Application No: AL/51/20/PL
Site Address: Tyrone House Norton Lane Norton Aldingbourne PO20 3NH
Description of Works: Demolition of existing house & outbuildings & erection of 1 No dwelling & garage (resubmission following AL/29/20/PL).

Liz Annalls
Environment Officer
Environmental Protection
Chichester District Council

PROPOSED GROUND FLOOR

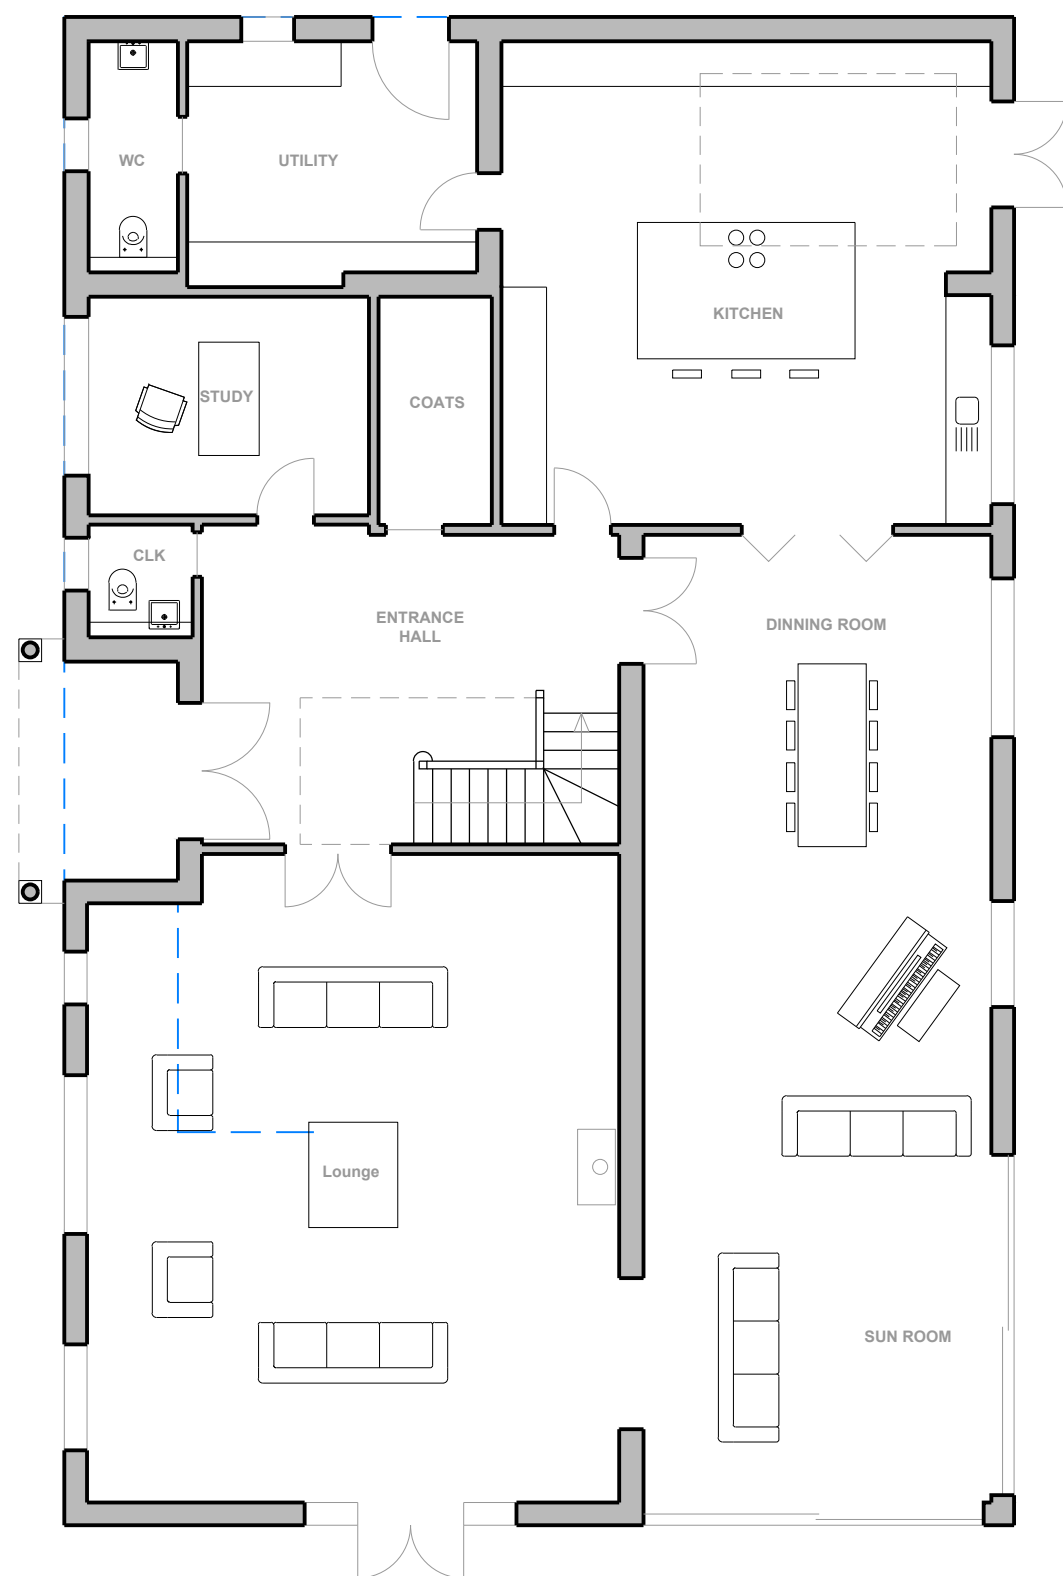
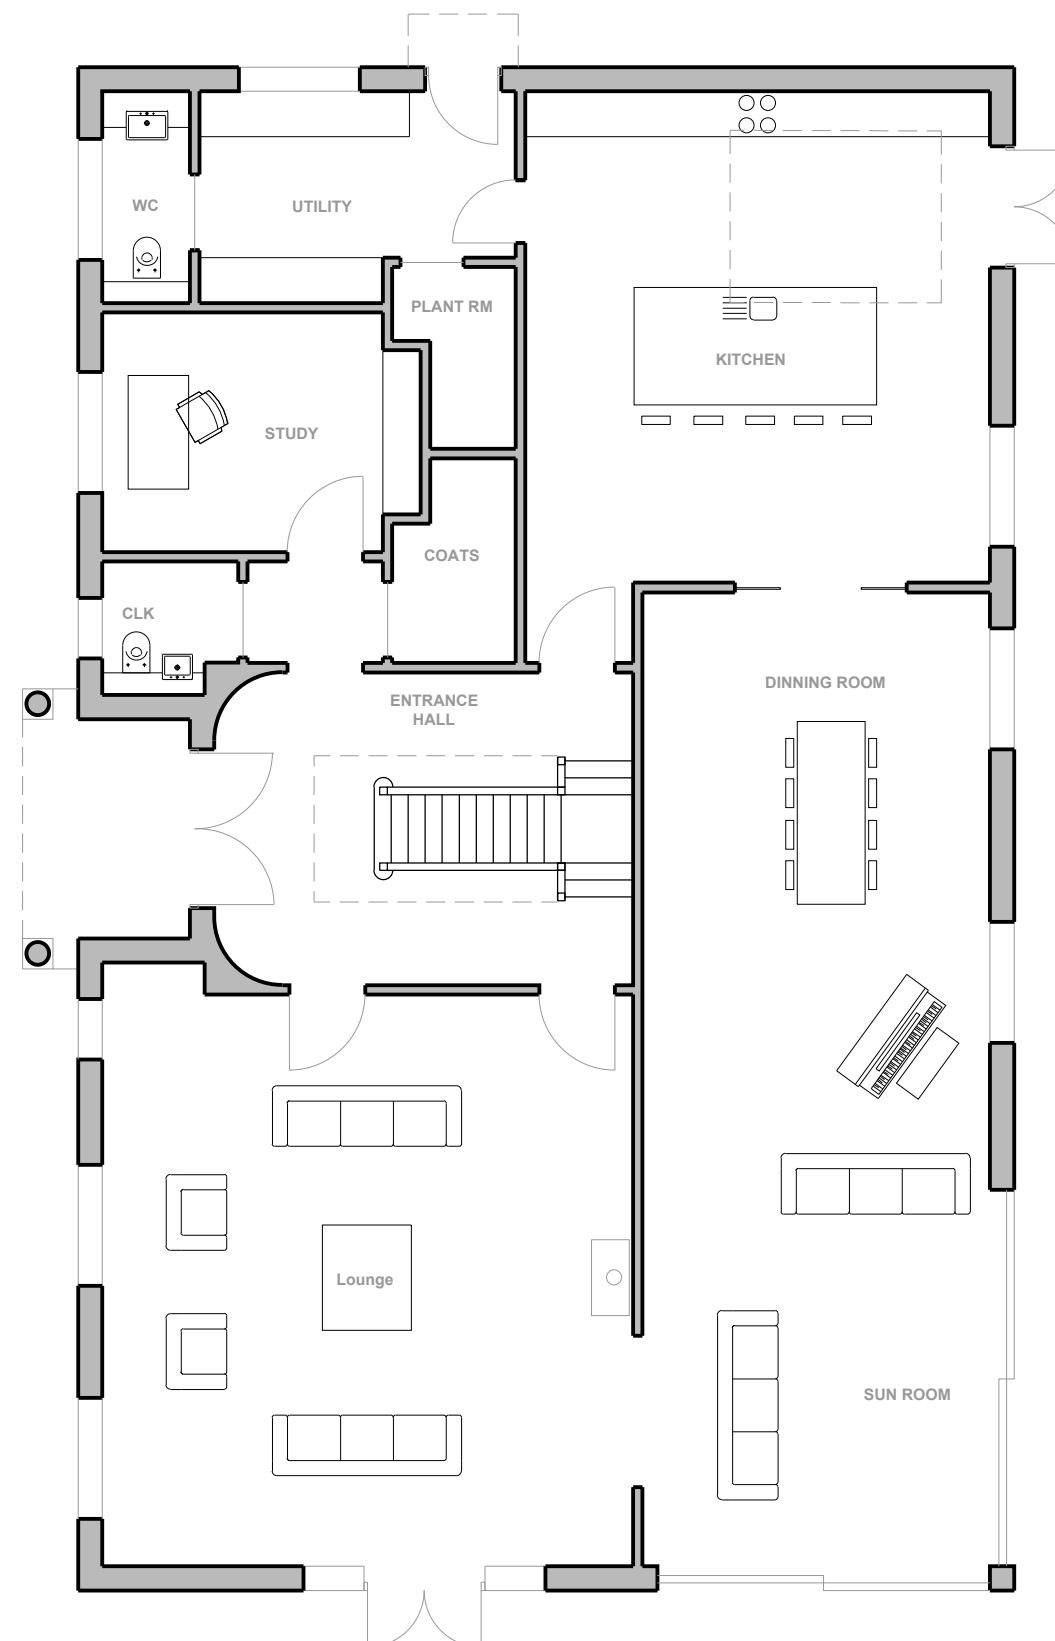
We require that a bat brick is integrated into the building onsite facing south/south westerly positioned 3-5m above ground.

We would like a bird box to be installed on the building / and or tree within the garden of the property.
